**CLEVE HILL SOLAR PARK – DEADLINE 4 SUBMISSION**

Following my submission at the Open Floor Hearing on 22 July, I wish to challenge a number of statements made in the Outline Construction Traffic Management Plan, Document reference: 6.4.14.1, Revision B, submitted by the Applicant for Deadline 3:

**Appendix E – Proposed Signage and Speed
Restrictions**

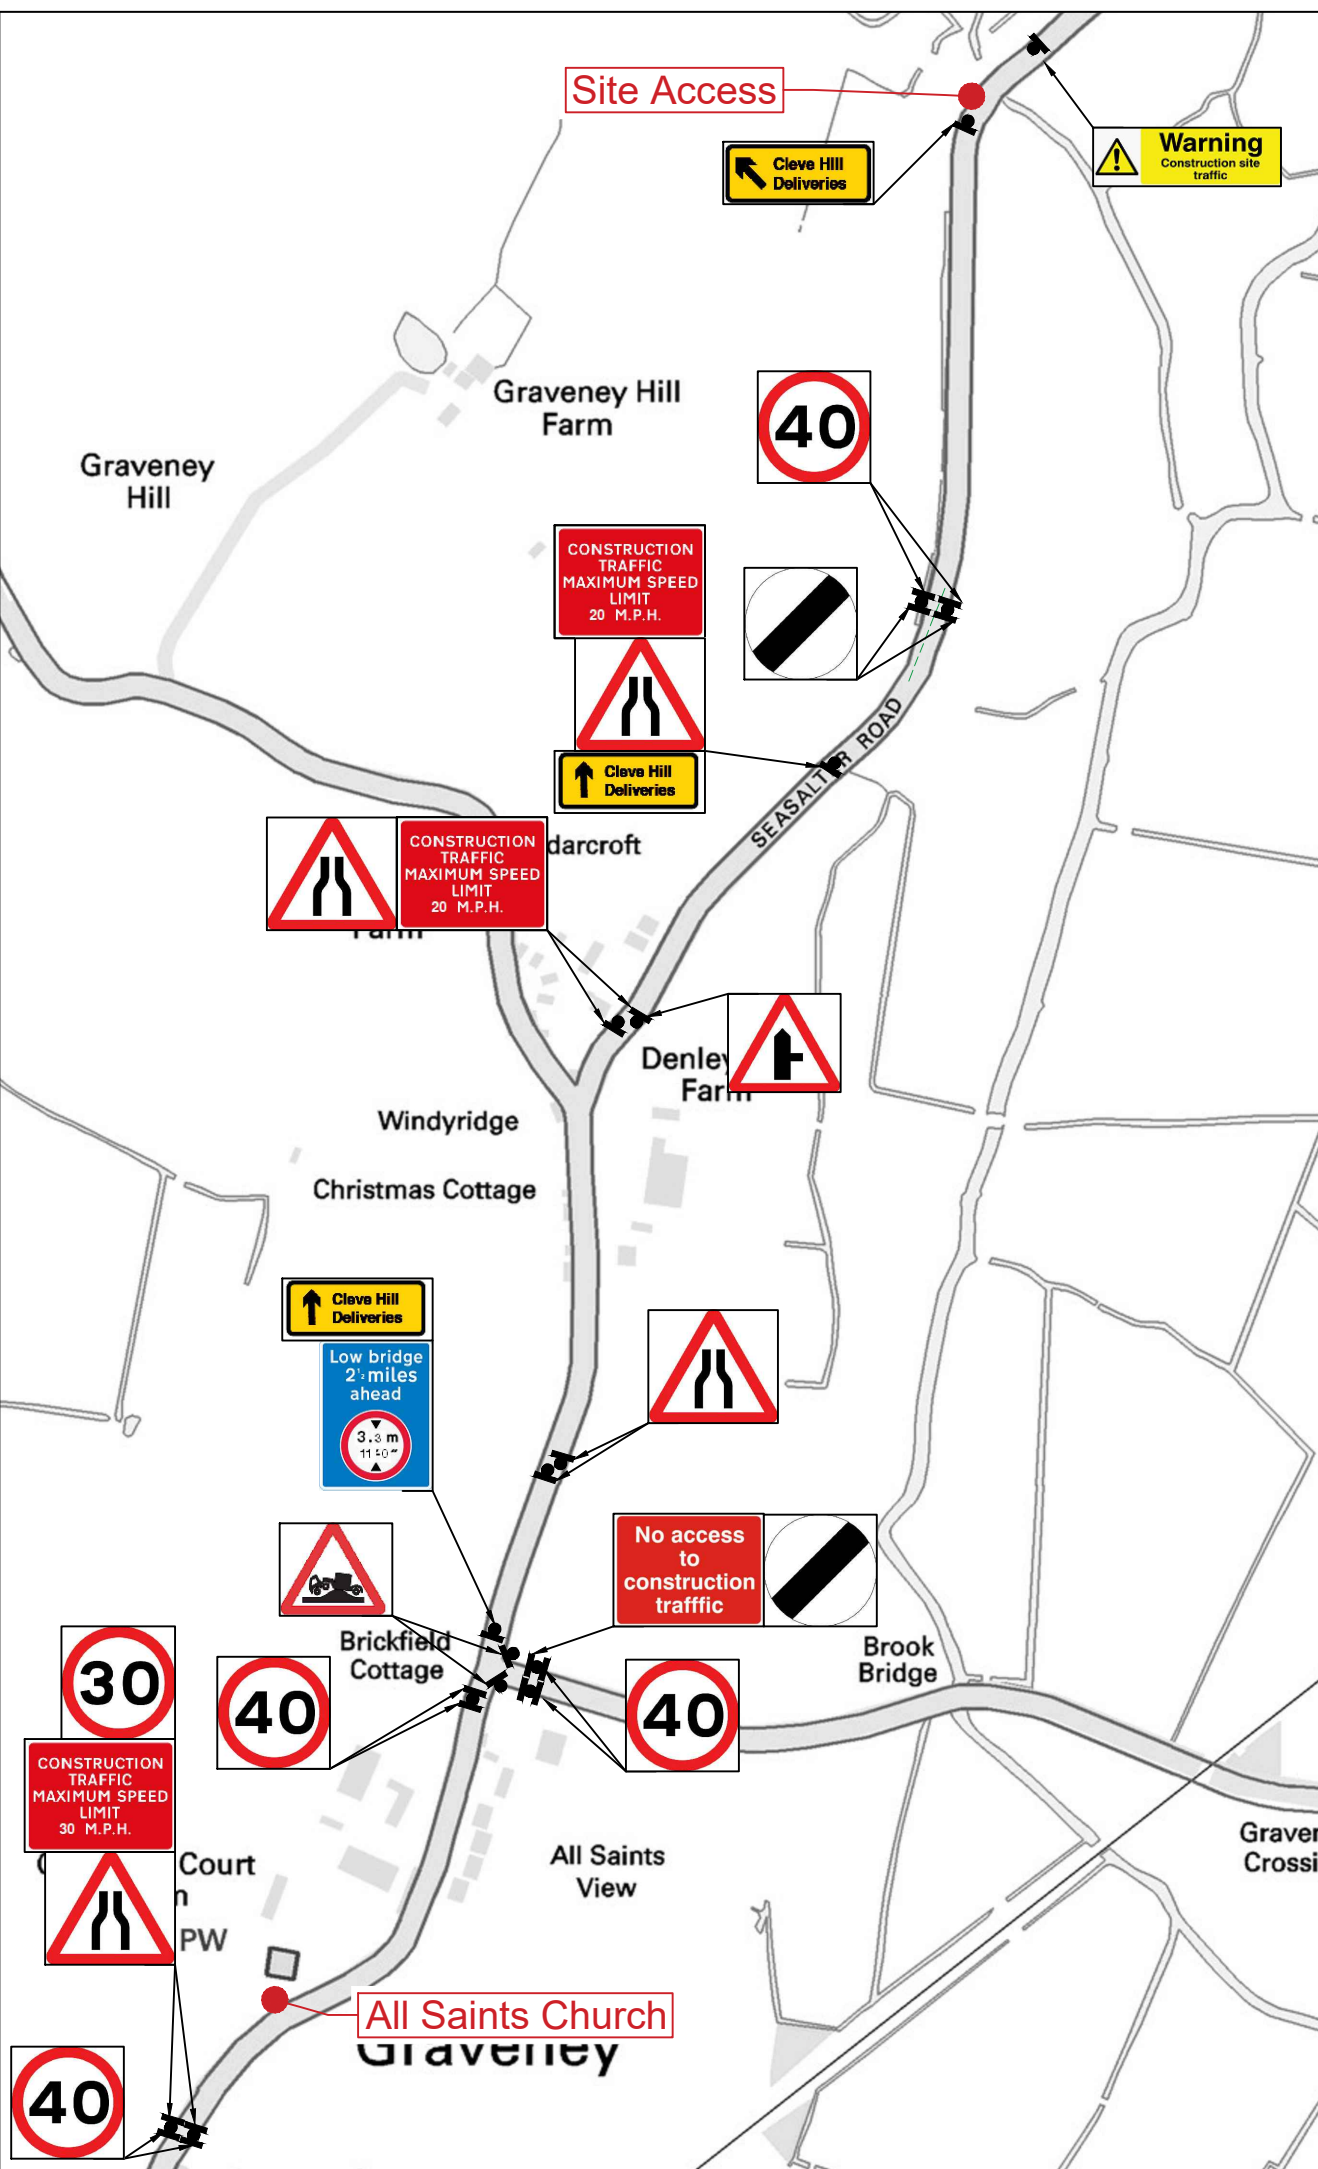
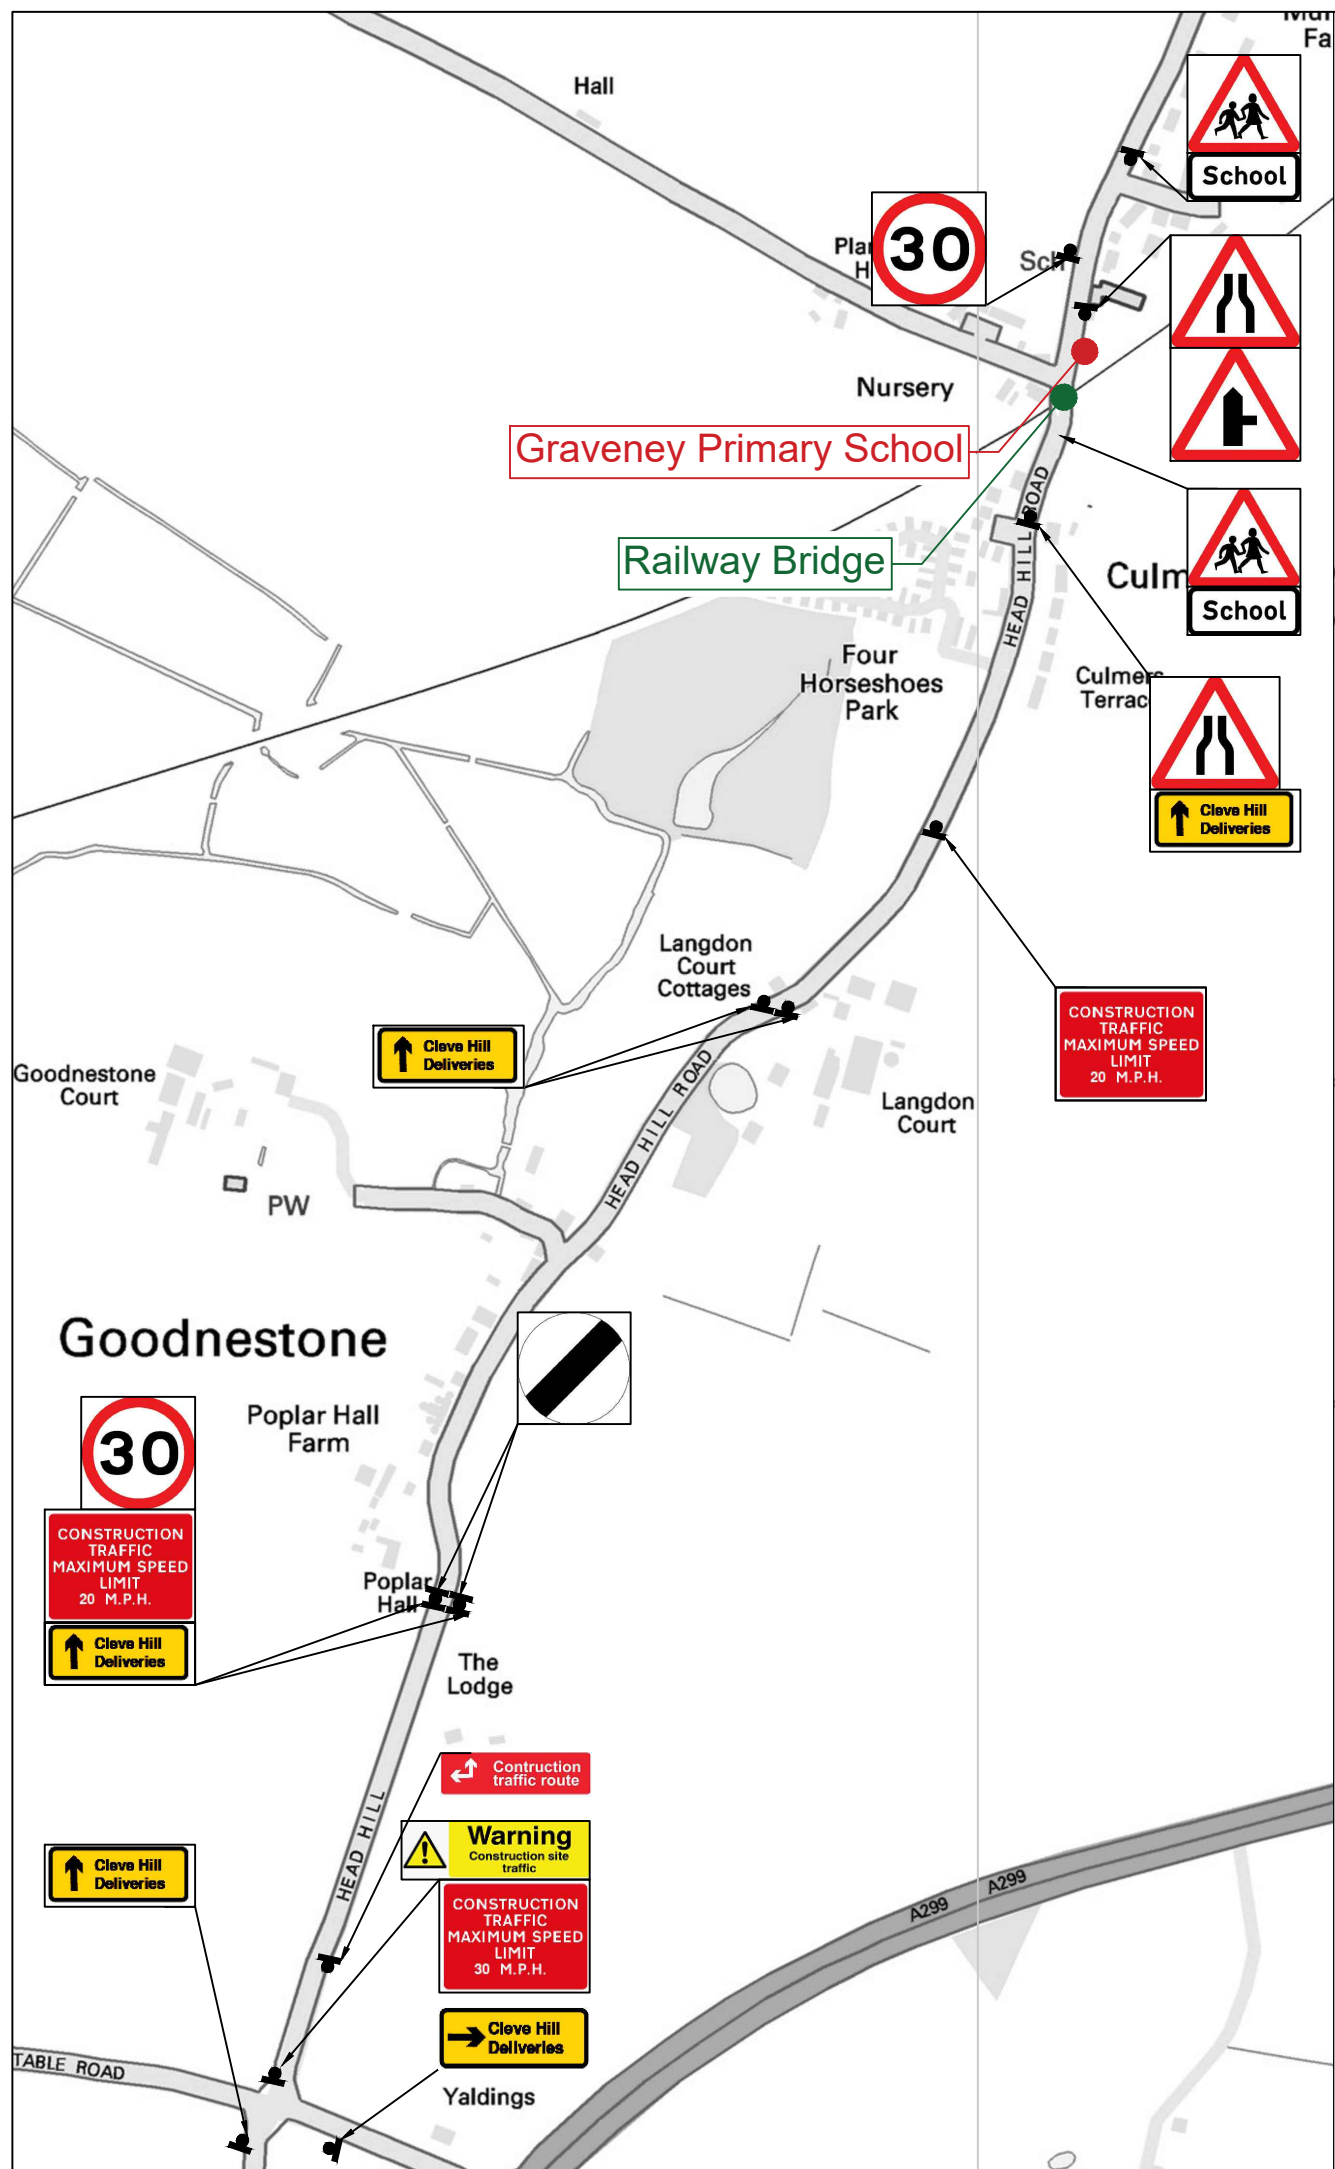
- Paragraph 6.9.2 states: “The locations of the proposed construction traffic speed restrictions are shown in Drawing 007 in Appendix E at the rear of this report.”

- **Could the Applicant please provide an explanation of this drawing as I have been unable to ascertain where the 20mph limits will apply?**
- Paragraph 6.12.3 states: “In the event that mud or debris is found on the public highway, a road cleaning contractor will be on call throughout the construction programme.”
